J Crittenden

16 December 2025

I am writing to object to SSD-96272465 (11-23 Rangers Avenue, Mosman) specifically as it concerns my property but also more generally because the EIS (and many of its supporting documents) contain substantial errors, omissions and misleading statements.

Figure 4 Proposed Site Plan

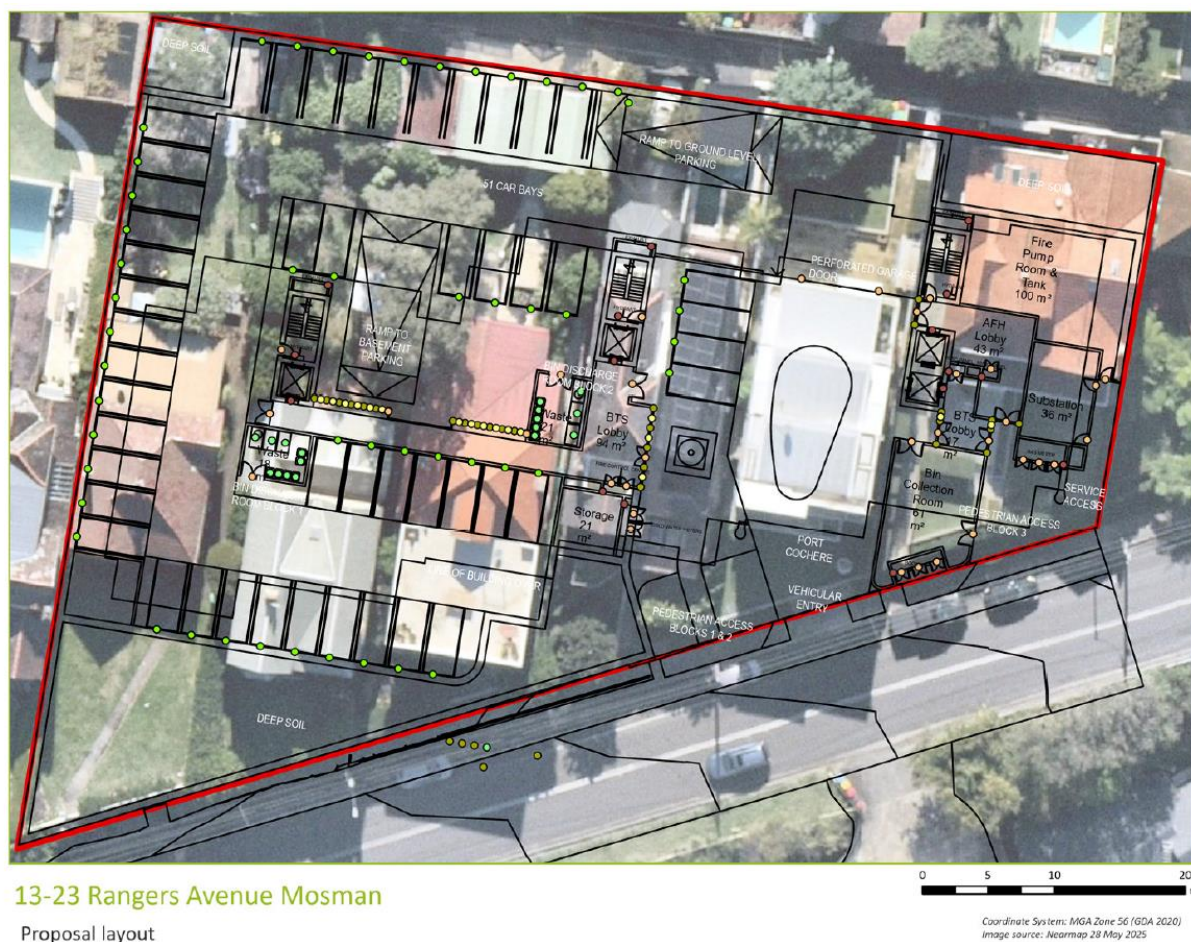
This statement underlines the fact that virtually all of the prospective built environment would have to be on the 9 Rangers Ave lot. This is the lot adjacent to 11-23 with its proposed 22.75 metres height with front and side setbacks of only 3 metres and an elevated, artificial “ground level” (by 2.943 metres) from the existing natural ground level at the boundary line. Given that the bulk of or indeed all reasonable potential development at 9 (& 9A) Rangers would occur on the irregular shaped 9 Rangers Ave site, there is no attempt to demonstrate how setbacks and an appropriate reasonable building envelope could be achieved in light of the current proposed development.

This is despite the eastern boundary only being 28.83 metres long. The EIS ignores the fact that no setbacks are needed on the western portion of the proposed development of these two (2) lots.

The most easterly of the three (3) proposed buildings comprises eight (8) storeys including a "ground level" that is 2.943 metres higher than the existing natural ground level. It has a separate entrance, separate strata plan and for all intents and purposes is an entirely separate development. It comprises 20 units or around 45% of the apartments concentrated on 27.97% of the site.

All waste services for the entire proposed development (ie two strata plans) are catered for, at street level, in close proximity to my south western boundary. This may mean that future reasonable development of 9 & 9A is not possible. However, the applicant has not prepared the type of envelope plans mentioned in the Karavellas judgement to demonstrate opportunities for future reasonable development.

The raised, artificial "ground level" (by 2.943 metres) adjoining my property has minimal landscaping and footpaths within the 3 metre setback proposed by the applicant. In effect, the current proposal makes my western front garden, including native ferns, the landscaping - in a sunken garden - for the proposed

A possible alternative would be to step down the developments from west to east in accord with the natural fall of the land, whilst adopting the true natural ground level at the eastern boundary.
